Rezoning Transportation Analysis

Petition Number: 2022-205

Date	Description
4-27-23	First Review (TM)
5-24-23	Second Review (DR)

Rezoning Plan
Petition # 2022-205

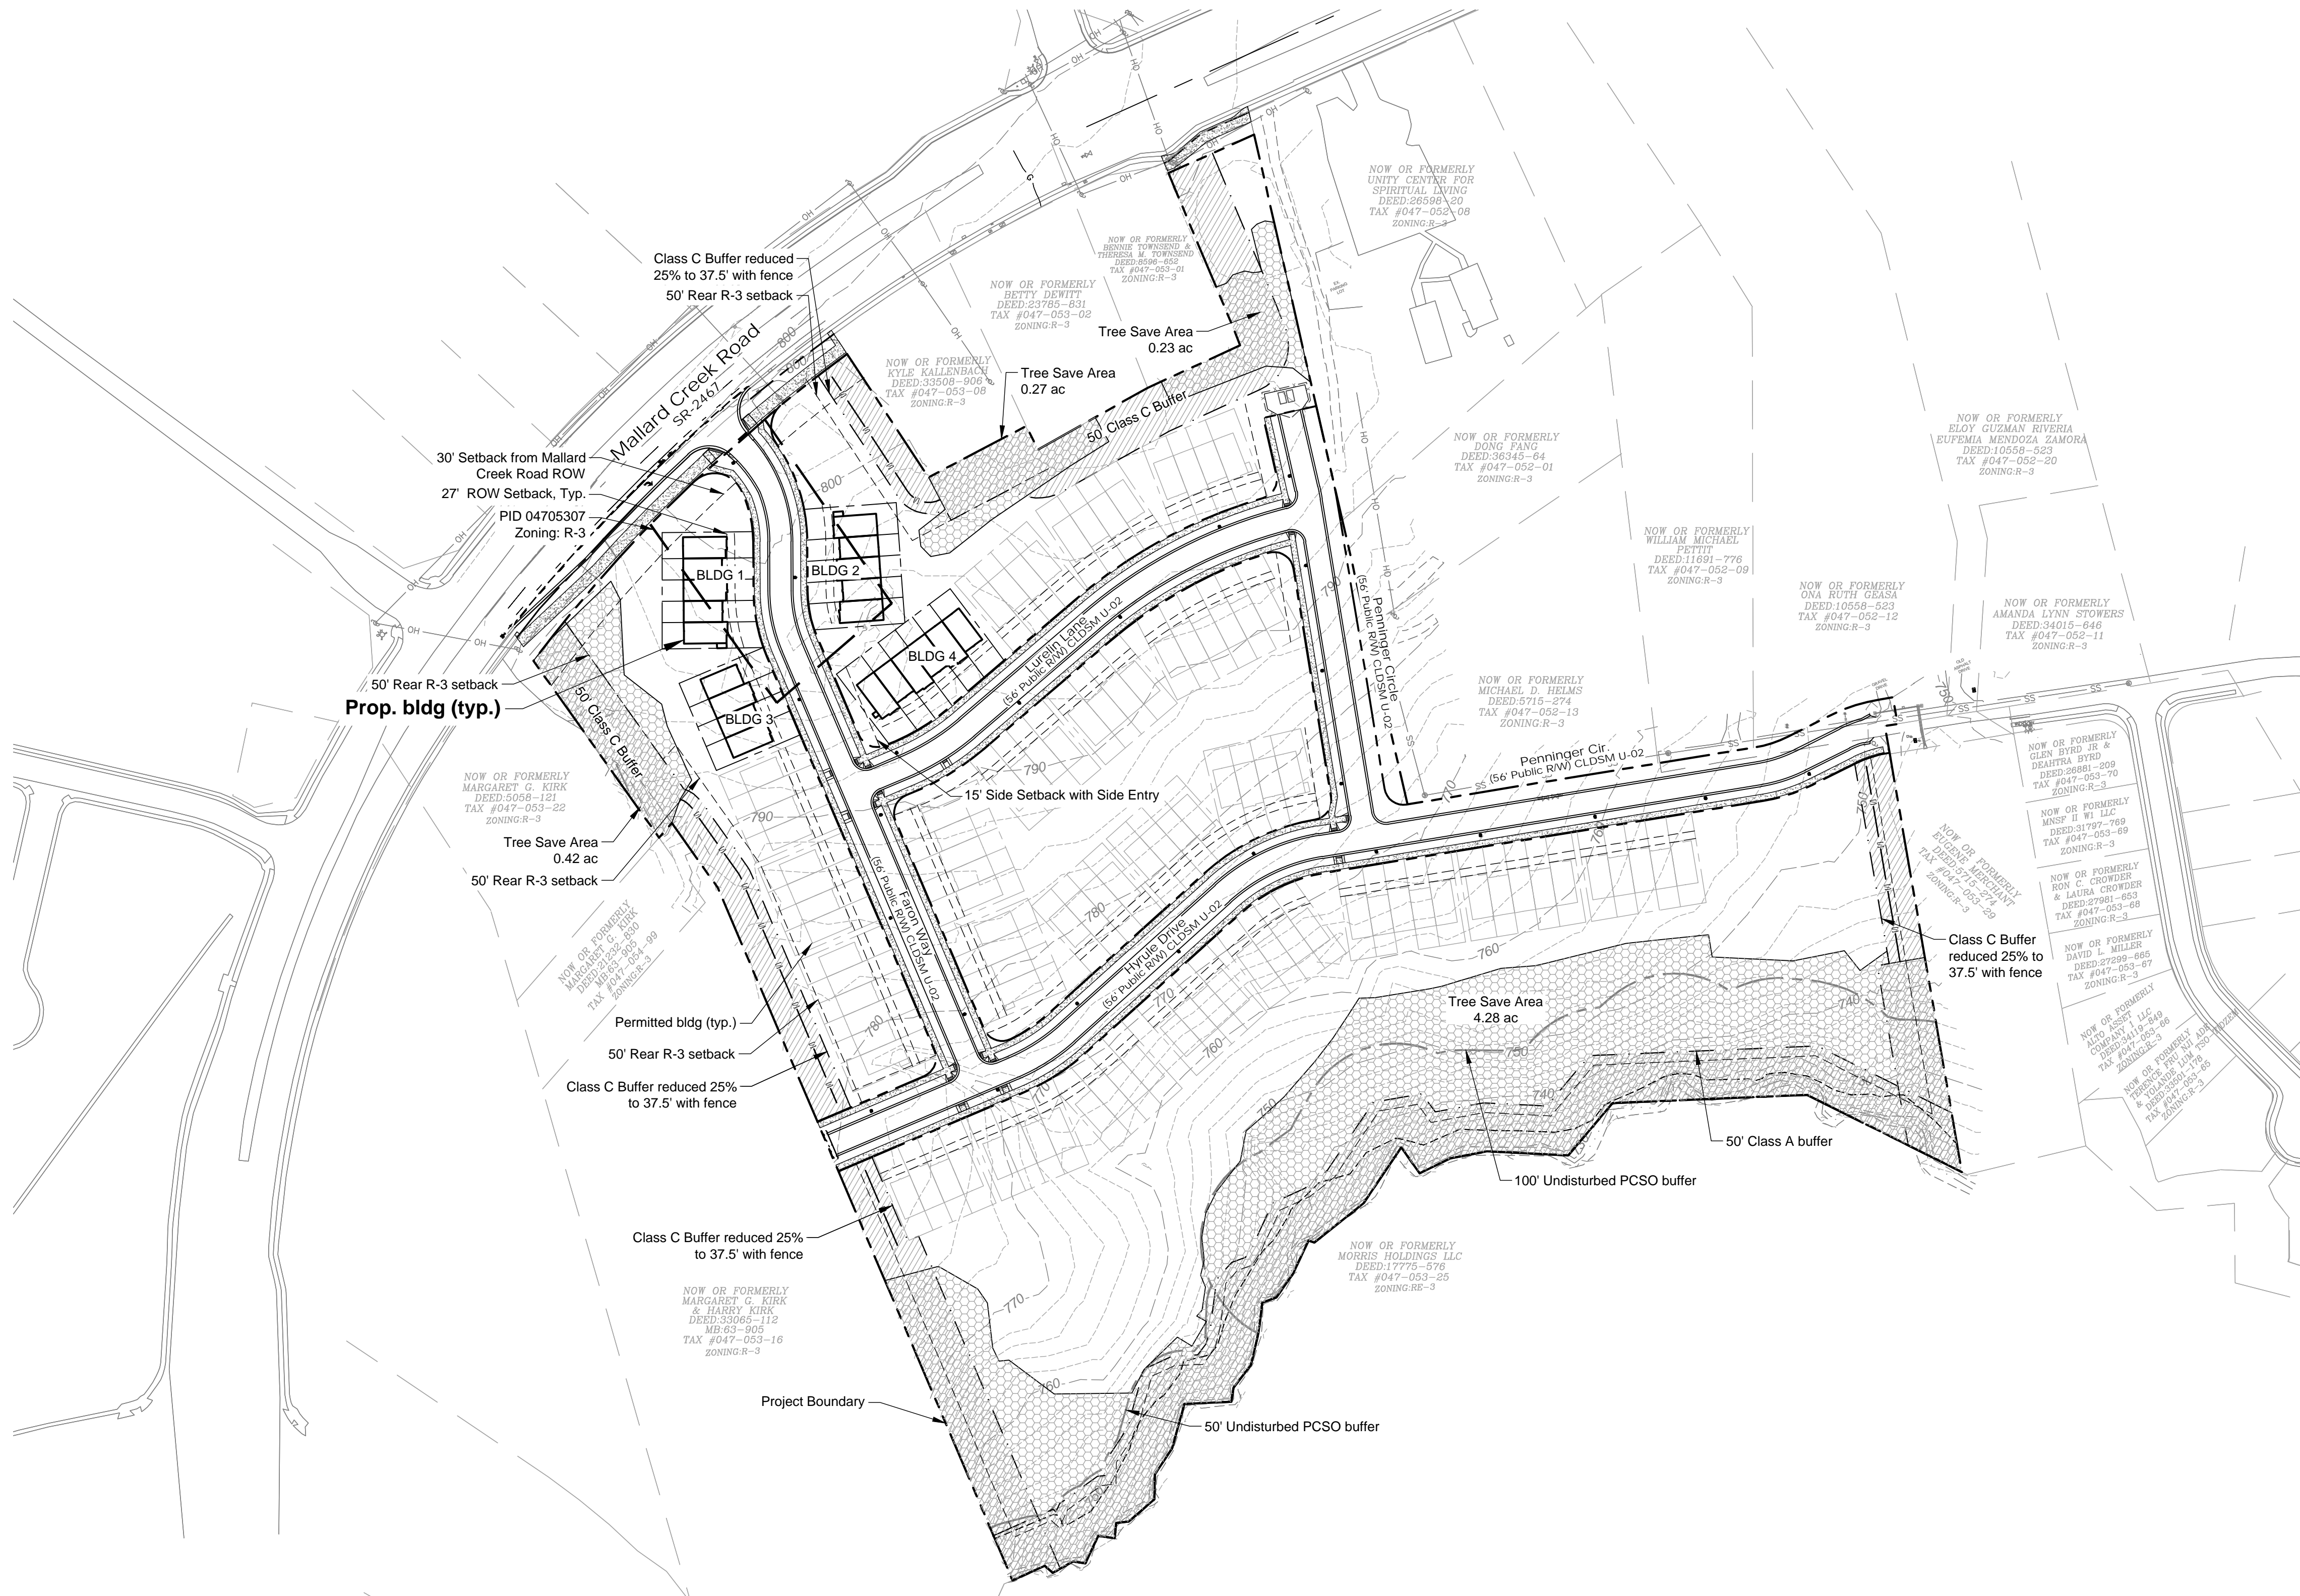
- Mallard Creek Road:** Location of curb and gutter to be moved to 33-feet from roadway centerline to accommodate the Charlotte Streets Map with a roadway typical section of 4+ Boulevard, Shared Use Path.

Outstanding Comment from 04-27-23: Label and dimension the curb and gutter from the centerline for each road on the site plan.

- Outstanding Comment from 04-27-23:** Revise site plan and conditional note(s) to commit to dedicate 50-feet of right-of-way from the road centerline. The site plan shall label and dimension the right-of-way from the road centerline.
